Town & Country Planning Act 1990 (as amended) s211 Notice

Prior Notification of Work to Tree(s) in a Conservation Area

Location: The Coast House Waterloo Road Felpham PO22 7EH

T1 to T4 to Prune

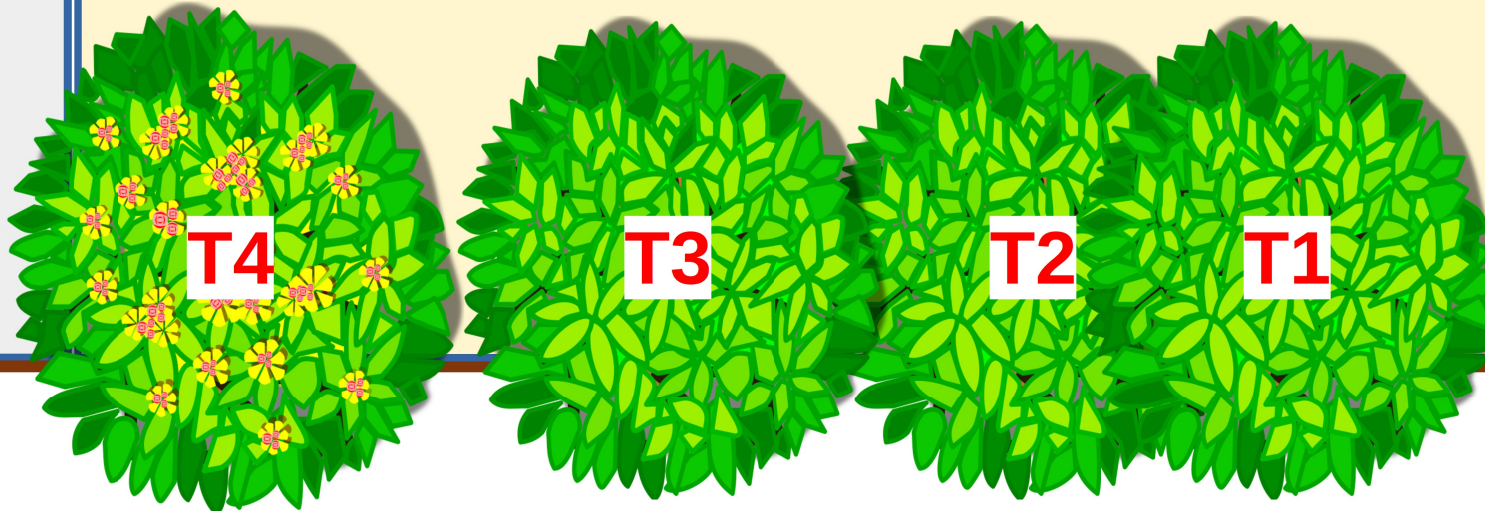
Please clarify the height and spread of the trees after the proposed reduction.
